CITY OF ALBUQUERQUE

April 22, 2022

RE: Slim Chicken
8240 Montgomery Blvd NE
Grading and Drainage Plans
Engineer's Stamp Date: 02/22/21
Hydrology File: G19D004E

Based upon the information provided in your submittal received 04/06/2022, the Grading & Drainage Plan **is not** approved for Building Permit and for action by the DRB on Site Plan for Building Permit. The following comments need to be addressed for approval of the above referenced project:

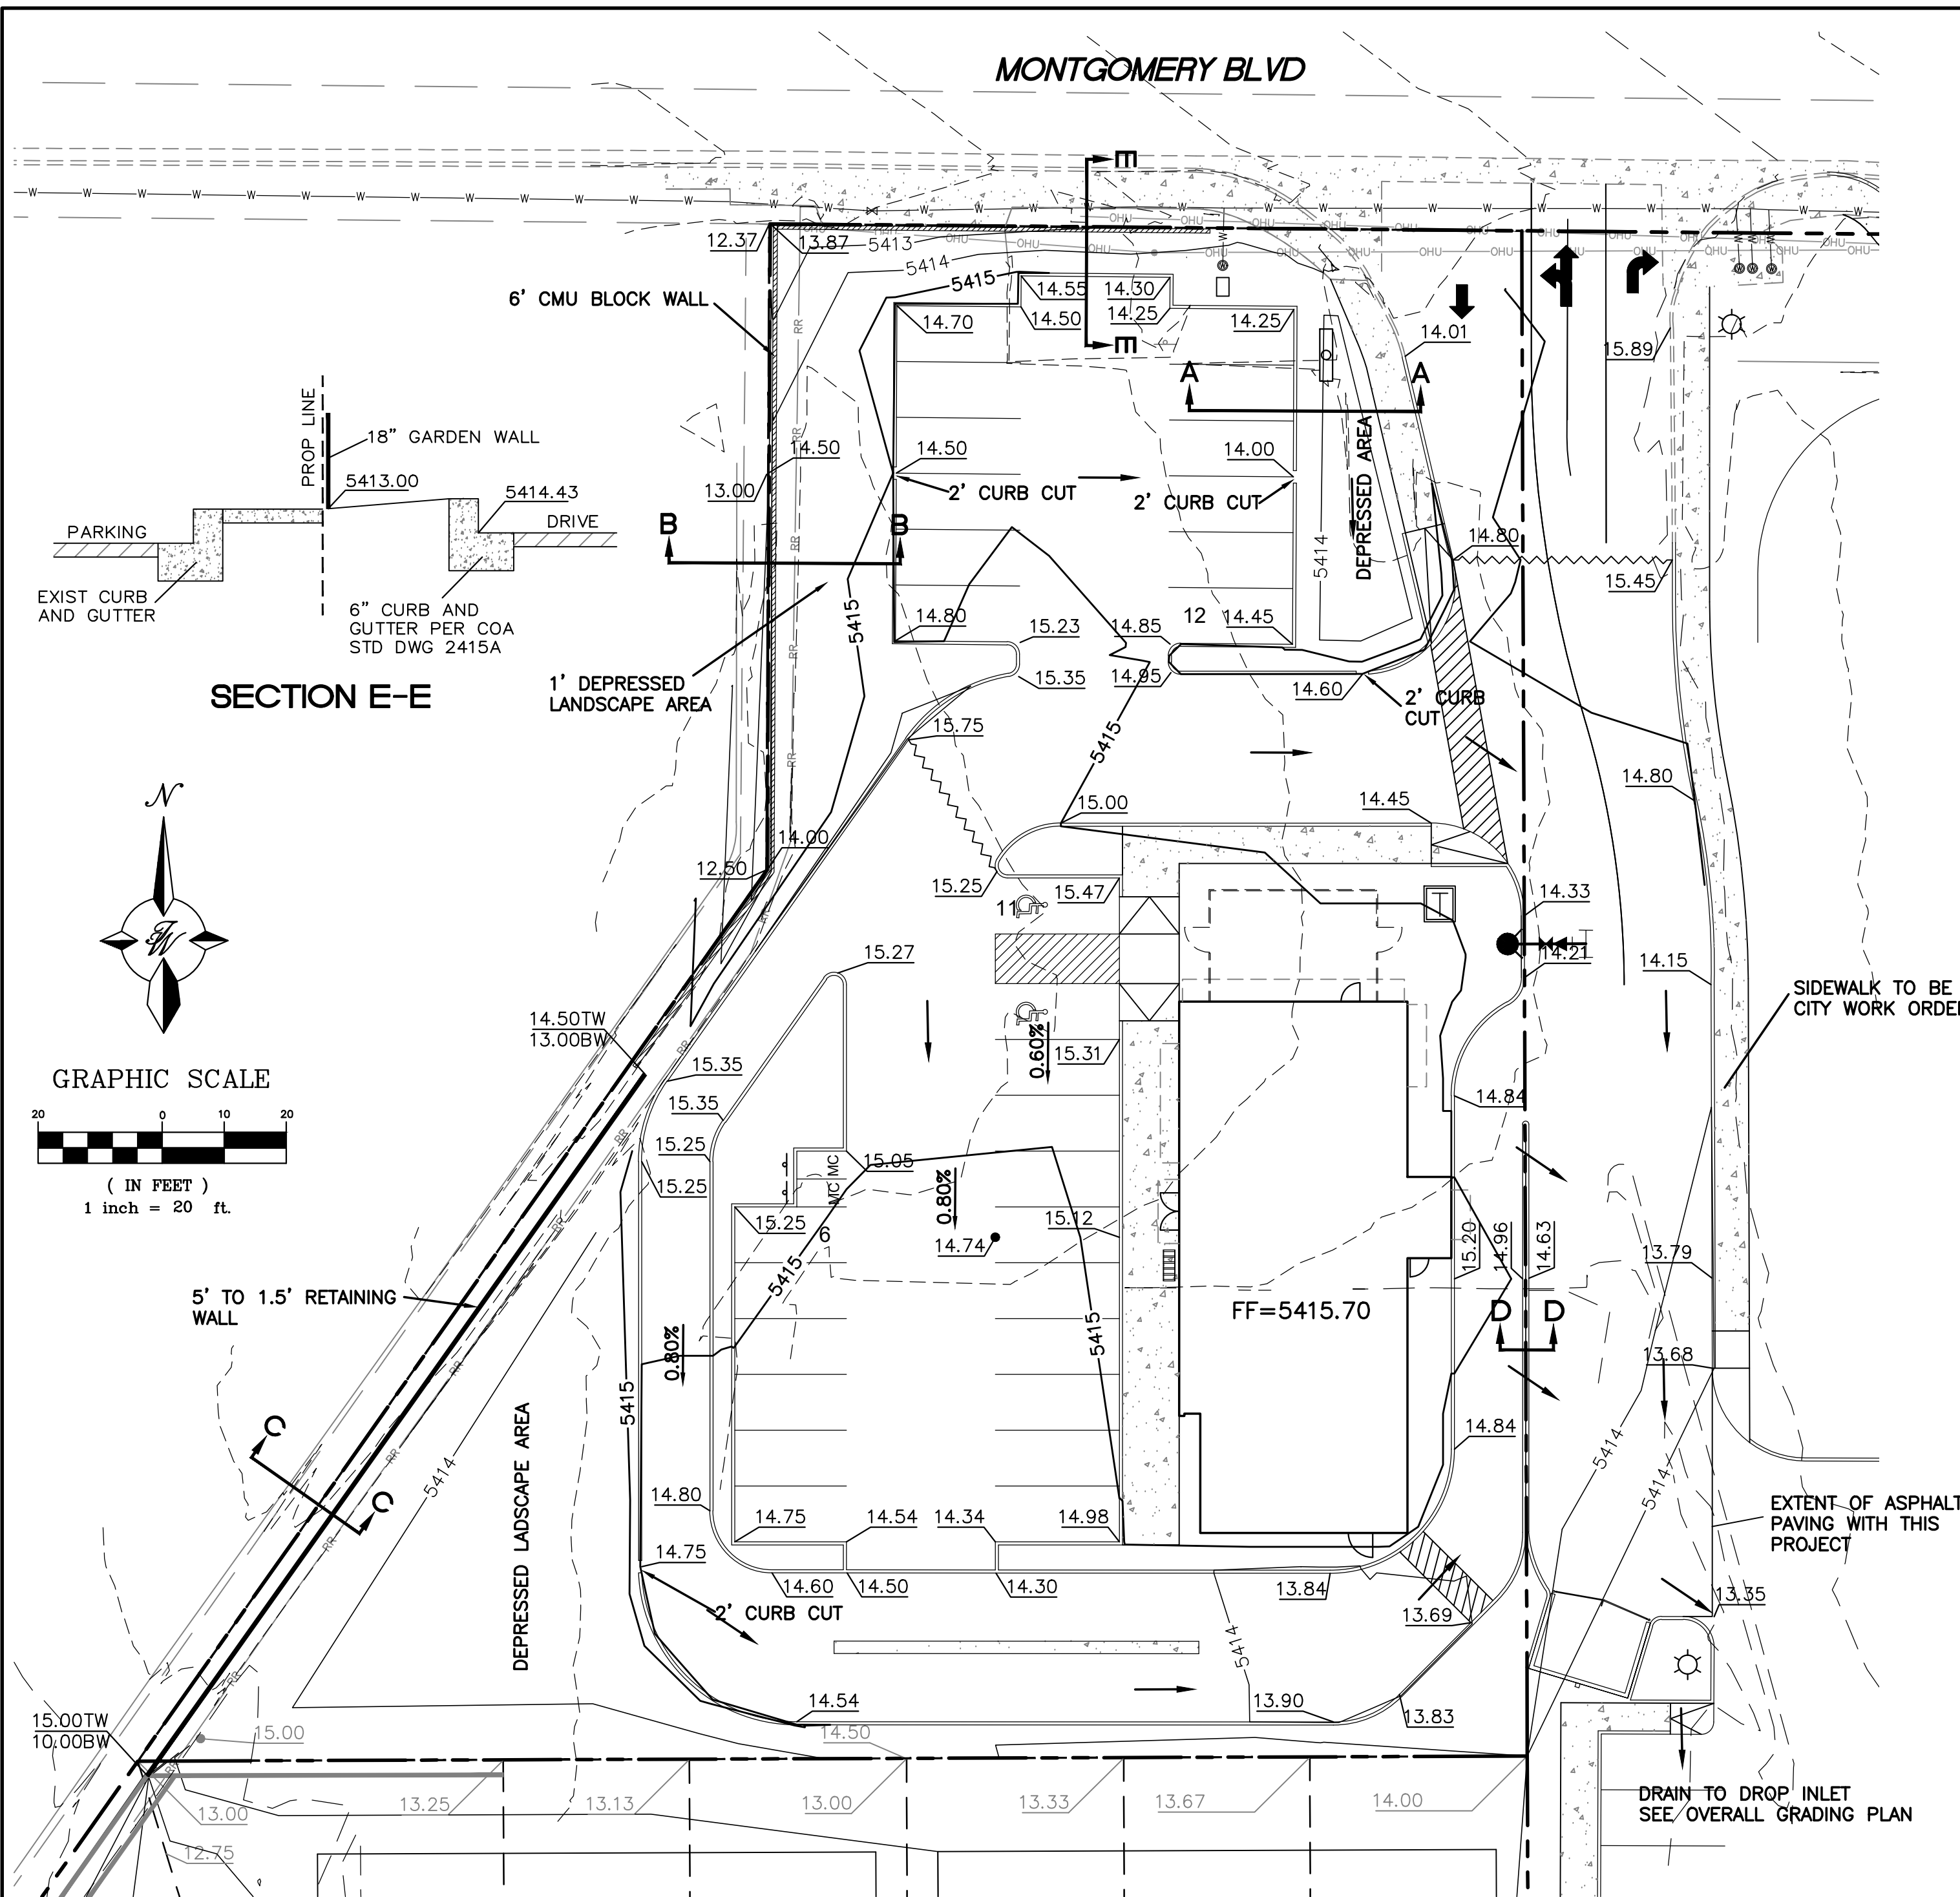
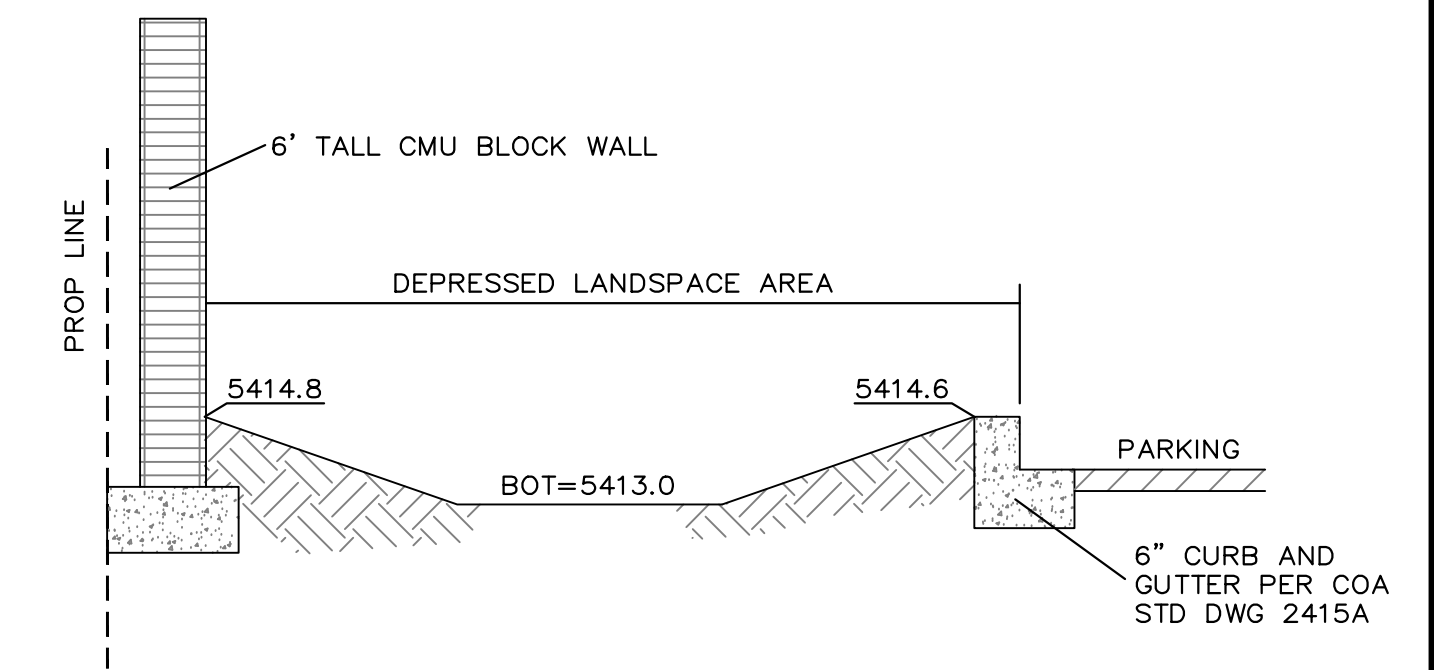
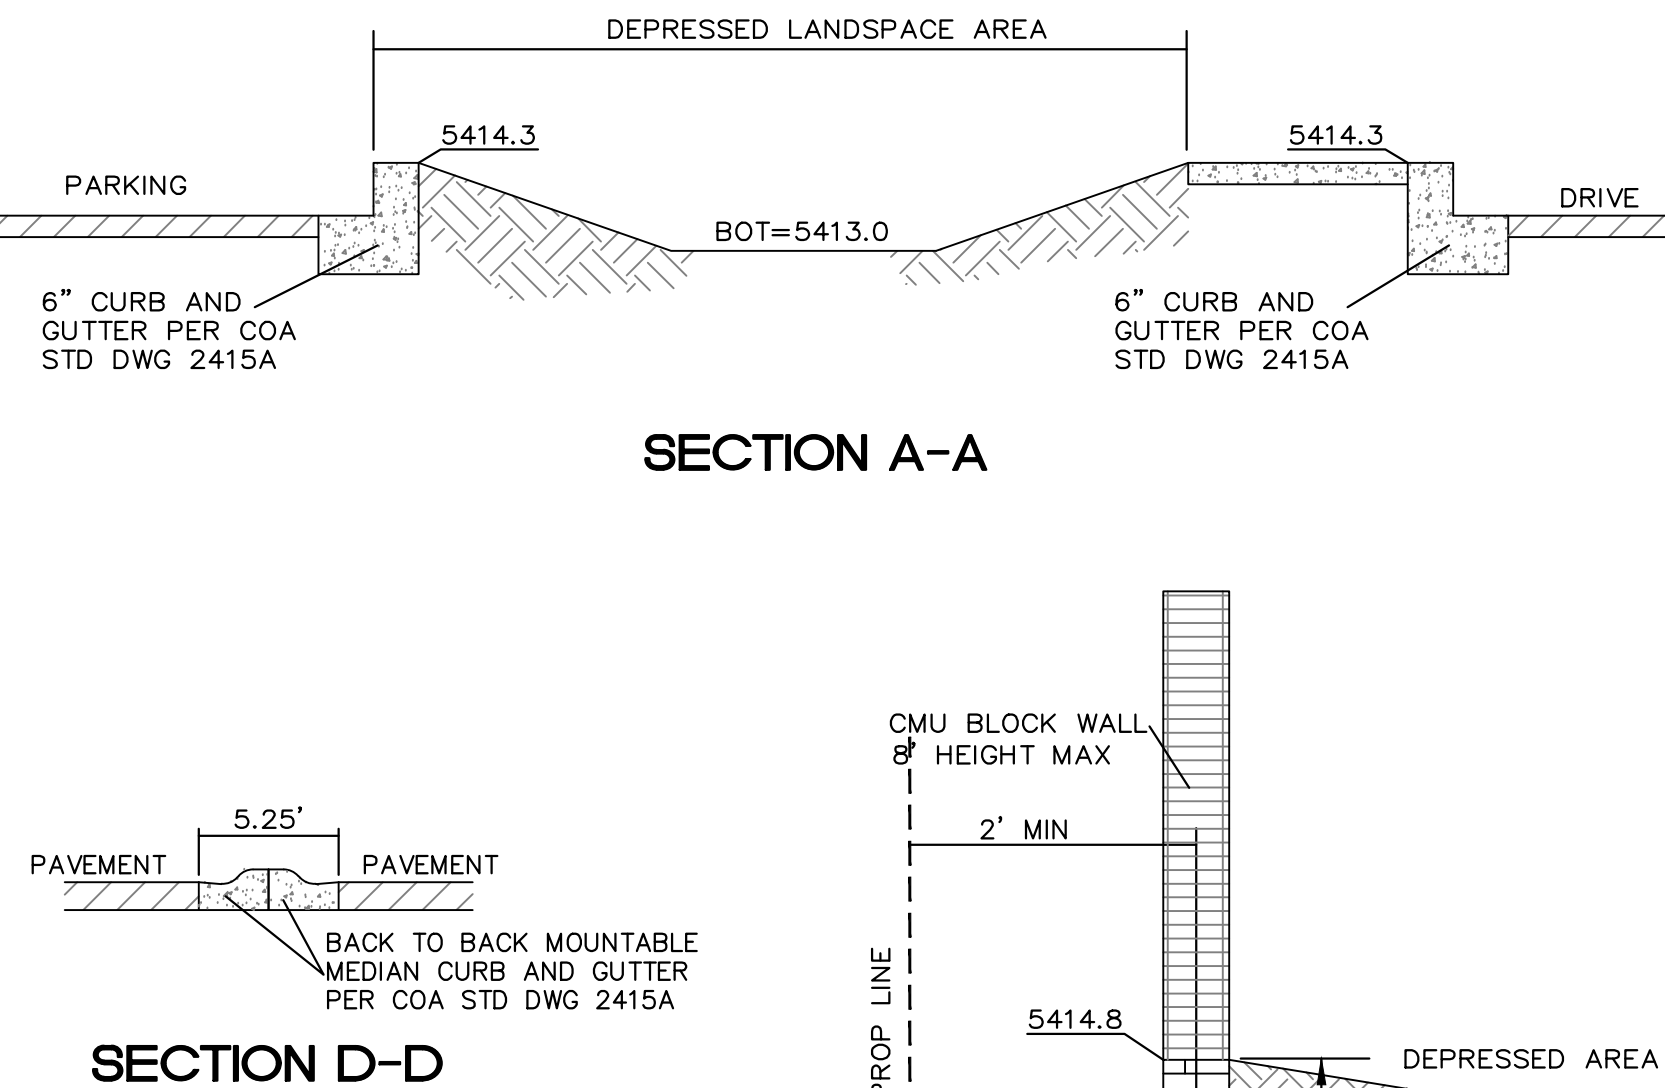
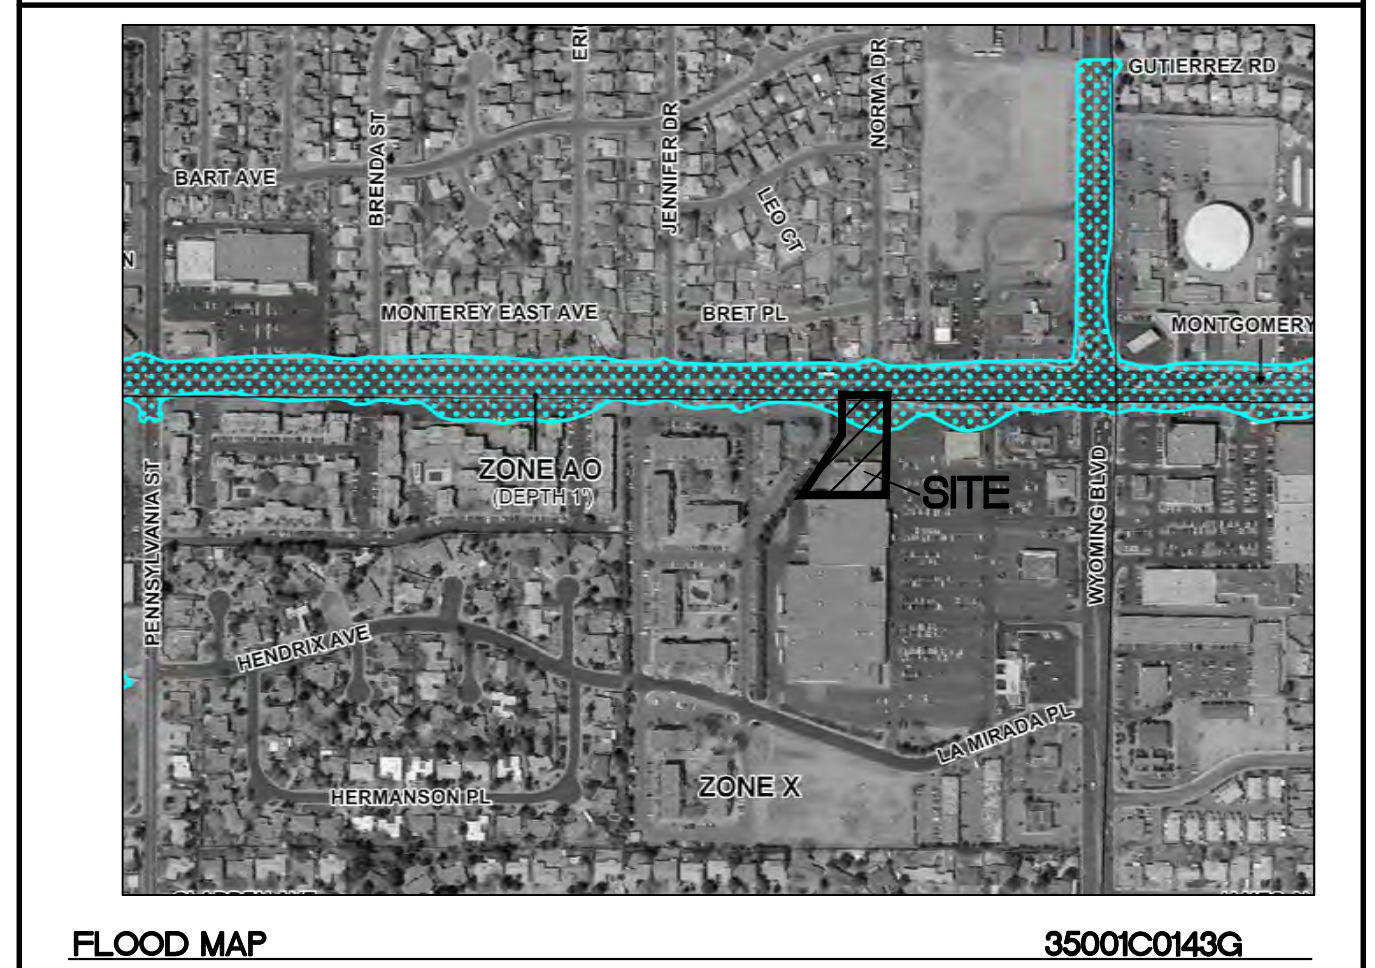
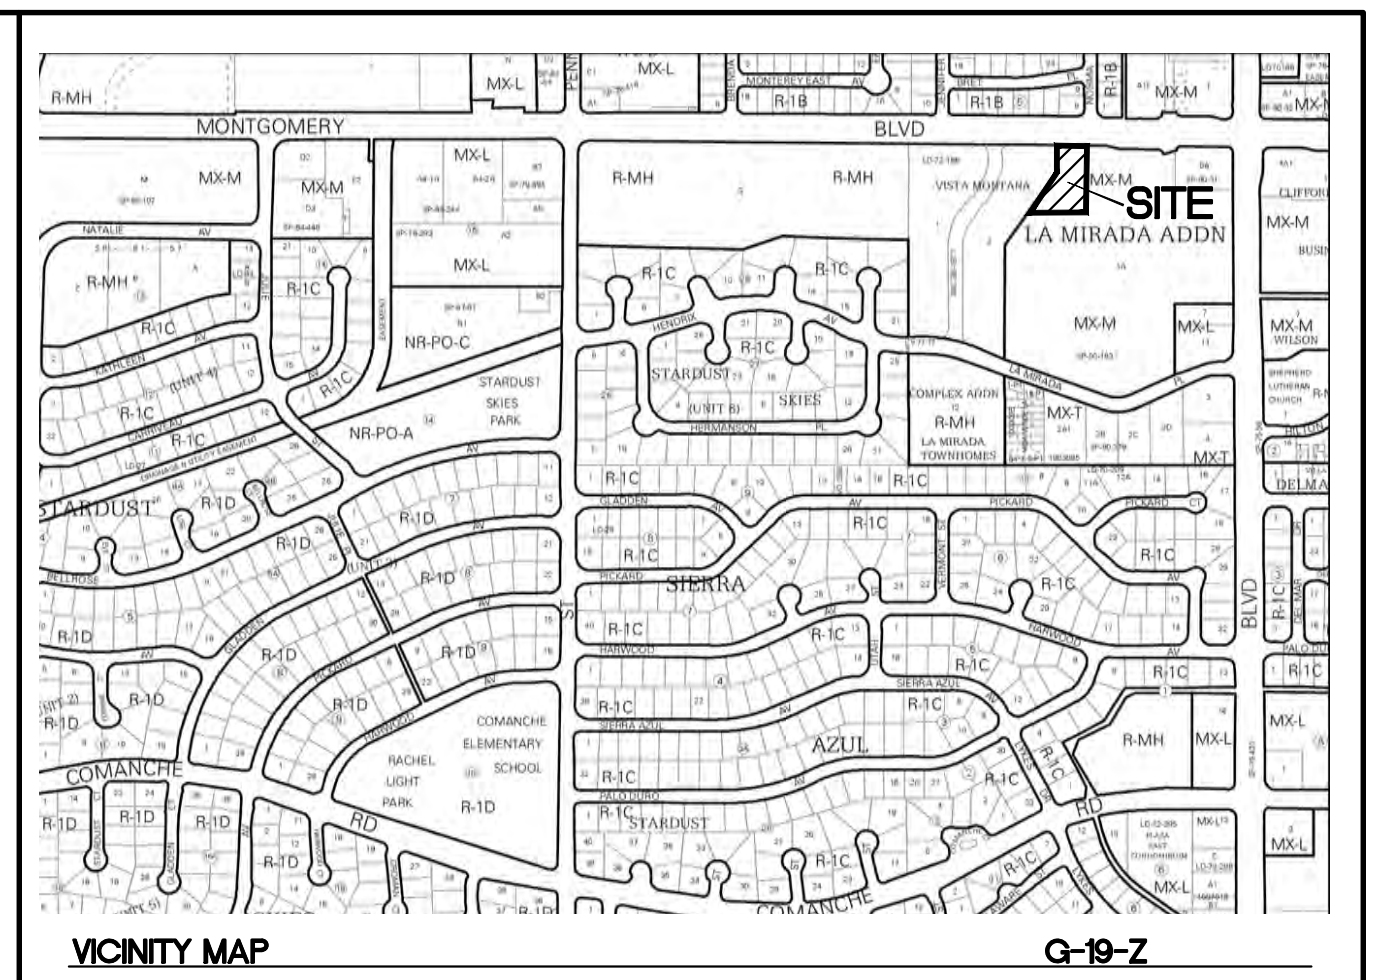
1. Please show the entire scope of the work to be done with this Permit. Below is the Approved Interim Grading & Drainage Plan for this Tract and entrance into Montgomery. Now show all the limits of the entrance. Most of this was demolished so that this site needs to build the entrance with curbs on both sides. The proposed sidewalk along the eastern part of the entrance needs to be labeled, "Sidewalk to be constructed un CPN # 568483. The existing line work within Montgomery needs to be shaded back so that the proposed work pops.

- Please add the flowline at the curb return at the Montgomery entrance.

- Where is the extent of the paving along the southeast corner of the development?

- There is a missing CMU block wall on the plan that is shown in Section B-B.

- Noticed that there is paving to be done on Tract B. It also appears that a majority of the drive (access road for the overall commercial) is on Tract B but should still be split between Tract A and Tract B. Please contact Transportation on this issue. Hydrology

will need written letter from the Owner of Tract B authorizing the work to be done within Tract. This letter needs to be notarized.

6. It appears that there is a lot of work on Tract B that should actually be on Tract A. This should slide over a little to make it work.

7. The separation between the drive-thru and the oncoming traffic from Montgomery should be a curb and not just stripped. Please contact Transportation for approval.

8. Please add both the existing conditions and the proposed condition calculations on the Grading & Drainage Plan. Reference to the overall development drainage manage plan is nice but the calculations are still needed on this sheet. The majority of Montgomery Blvd is not need, so the calculations can be place there.

9. Please provide the weir calculations, per DPM Article 6-16(A), for the curb cuts. A coefficient of 2.7 is typically used for the weir equation $Q = CLH^{2/3}$.

10. The entire Tract A needs to follow the approved overall development drainage management plan. See the wording below form that plan.

COMMERCIAL BASIN "A" AND "B" WILL DRAIN SOUTH TO A PROPOSED DROP INLET LOCATED JUST NORTH OF WYMONT CIRCLE. THOSE FLOWS WILL BE CONVEYED THROUGH STORM SEWER TO THE WATER QUALITY POND. BASIN "C" WILL DISCHARGE TO A PROPOSED DROP INLET AT THE ENTRANCE ON MONTGOMERY AND DRAIN VIA STORM SEWER TO THE DROP INLET THAT CAPTURES BASINS "A" & "B".

This site currently violates this approved plan with curb cuts into depressed landscaping areas that do not drain anywhere or drains into Montgomery Blvd which is not allowed.
